AIRPETS, SPOUT LANE NORTH HEATHROW

NEW SECURITY GATES AND PERIMETER SECURITY FENCING

Stage 1 Road Safety Audit

DC-RW-26-5104-RSA1

Plan of Entrance Gates - (Symbolic)

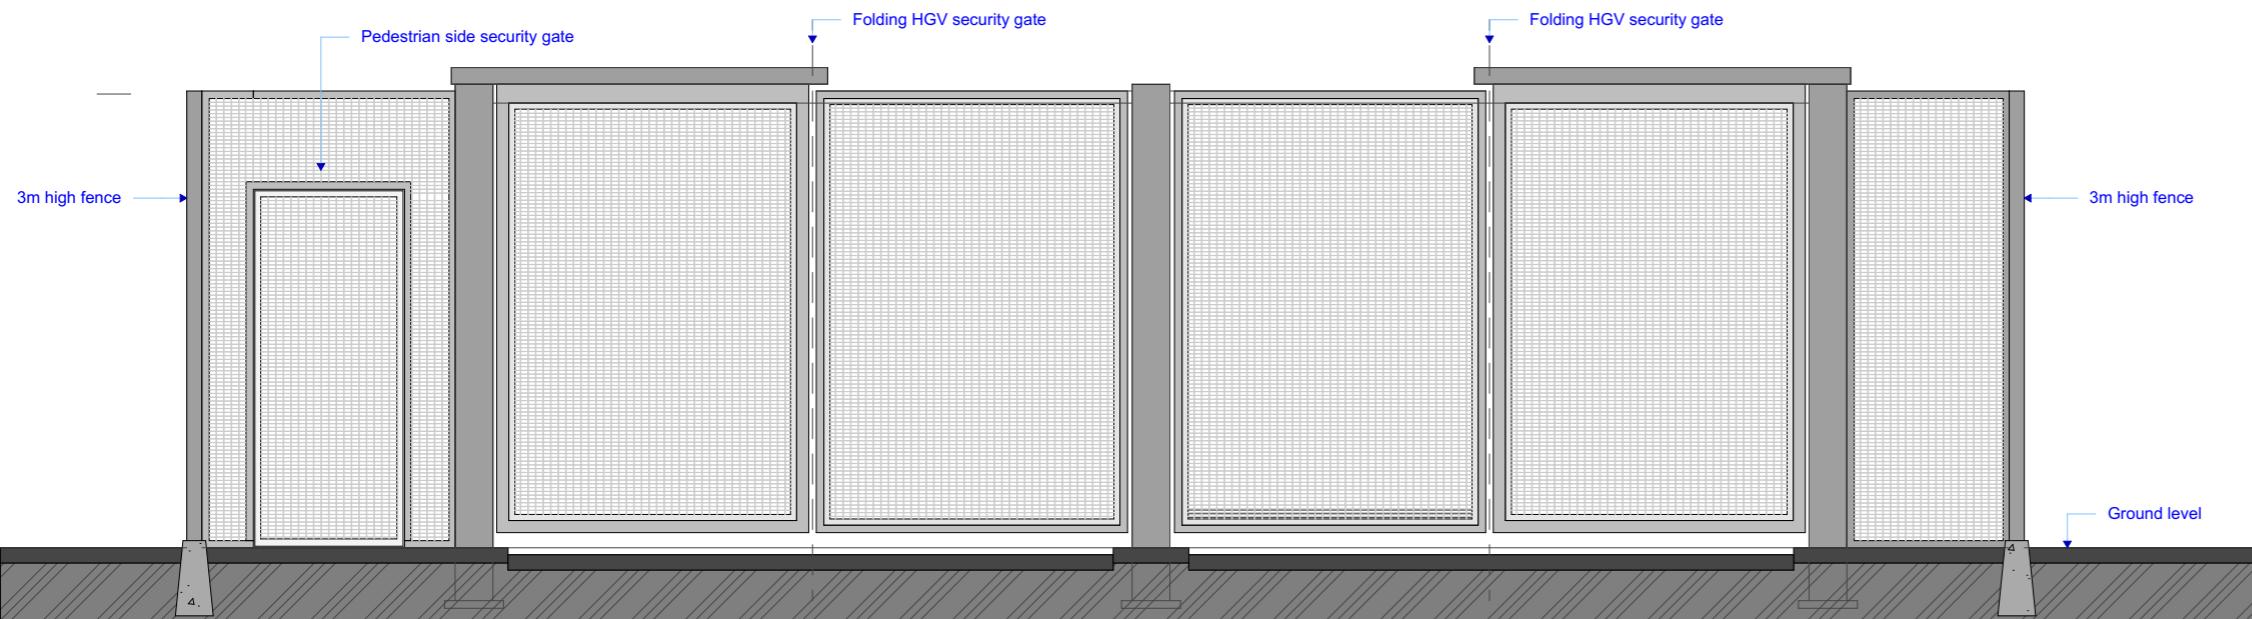
The audit team noted with the existing gates that visitors may position themselves too close to the gates to allow them to operate. With the airlock gates, longer vehicles who may stop, too close to the gate, may then have to reverse, presenting a risk of collision with other vehicles on Spout Lane North.

Provide a “wait here until gate opens” type sign and road marking.

DRAWING TITLE: **Proposed Access Engineering Layout Option 1**

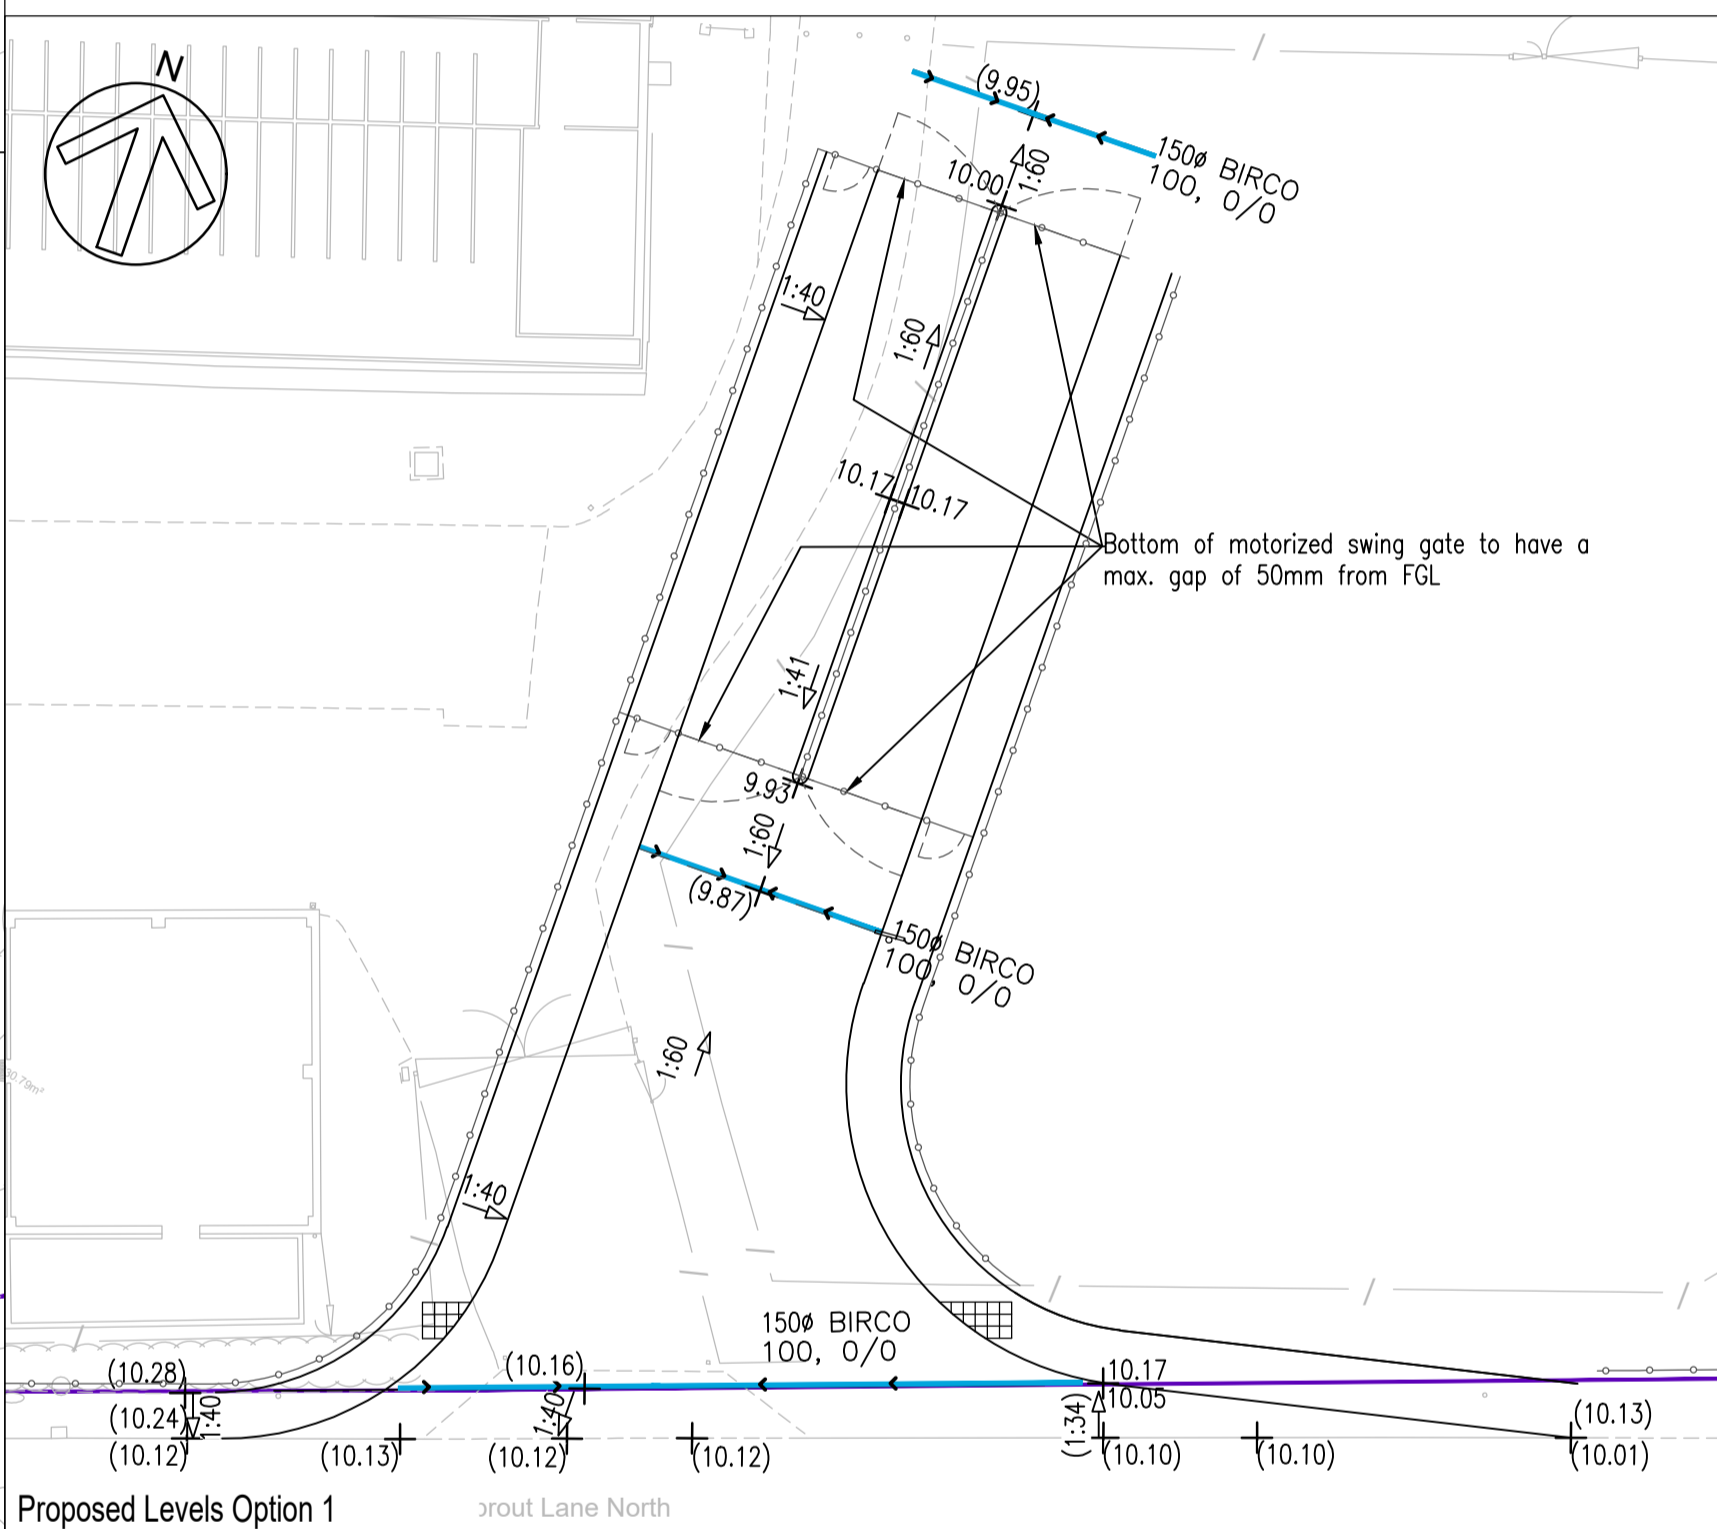
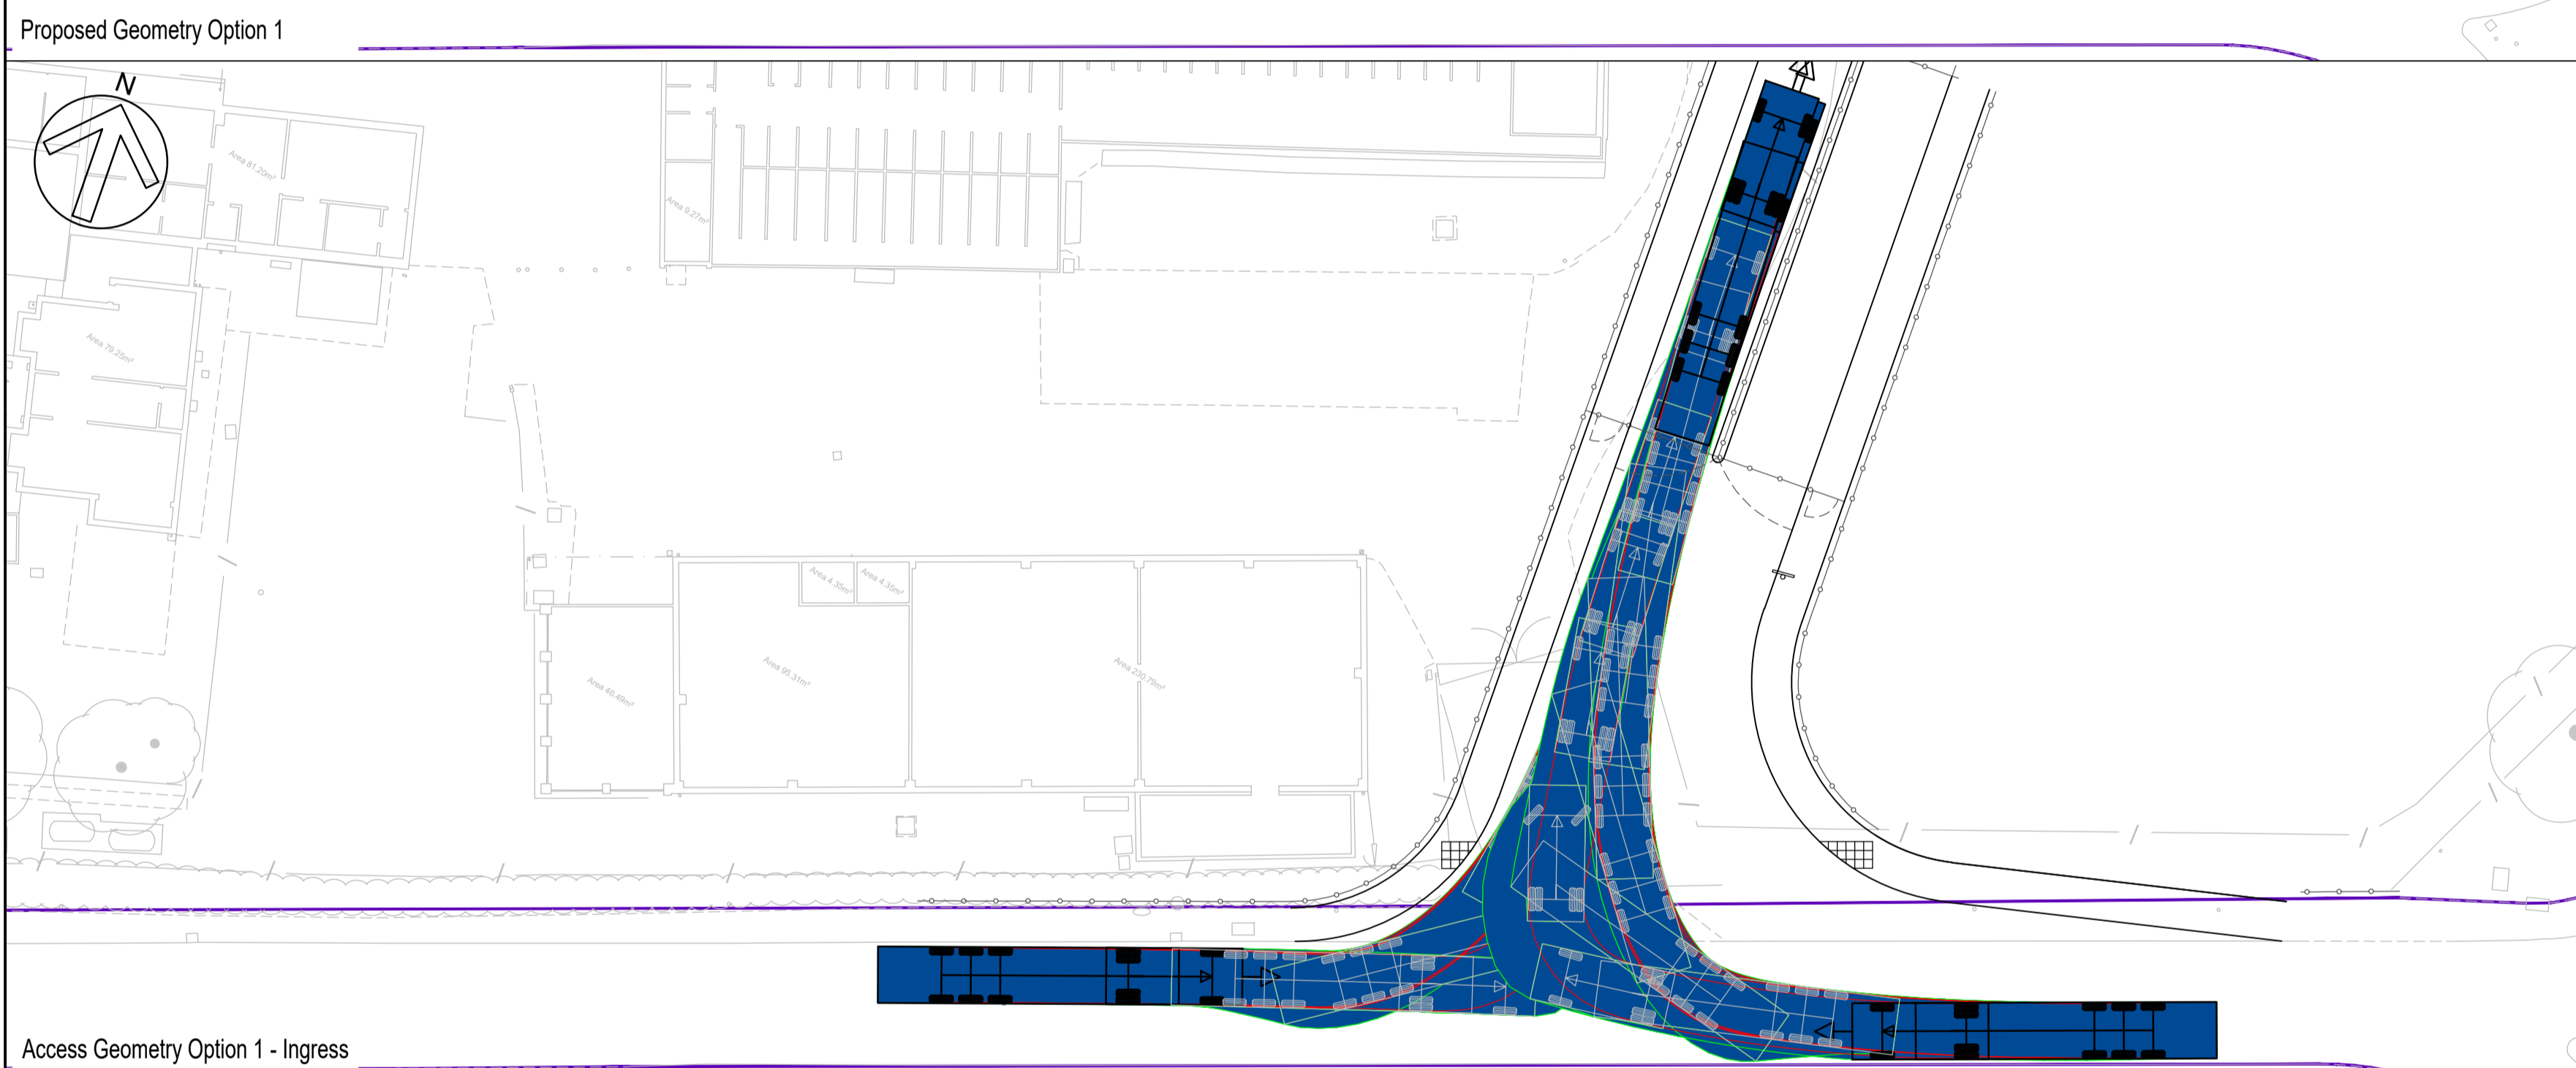
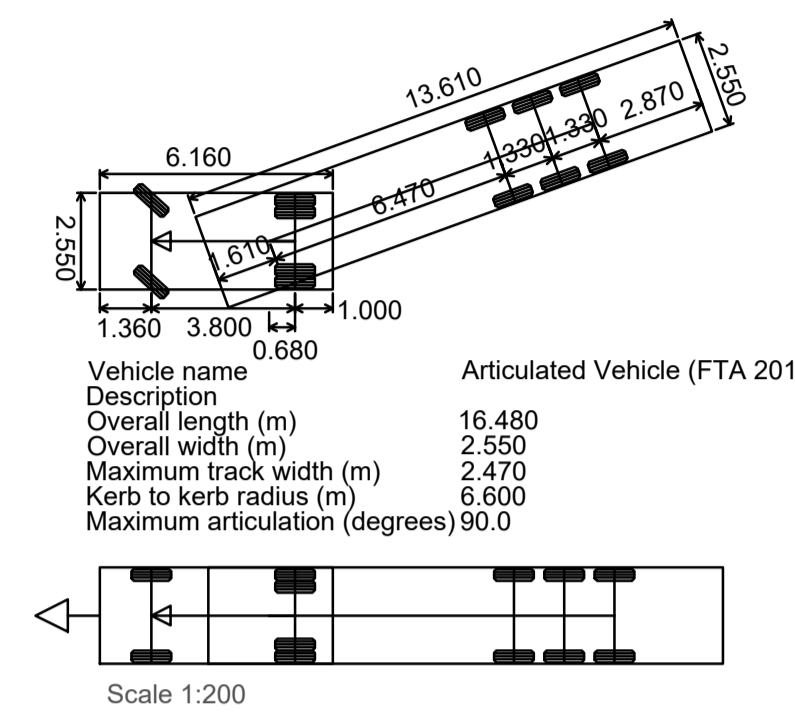
With the alignment of the access road, if a vehicle is leaving the site at the same time as one wants to enter it is more difficult due to the alignment. The inbound vehicle may choose to reverse, which may result in a collision with traffic on the public highway. If there was good intervisibility the inbound vehicle would be able to see oncoming vehicles leaving the site, and wait clear of the exit.

Provide intervisibility between exiting and entering vehicles, to allow vehicles to safely manoeuvre in and out of the site.
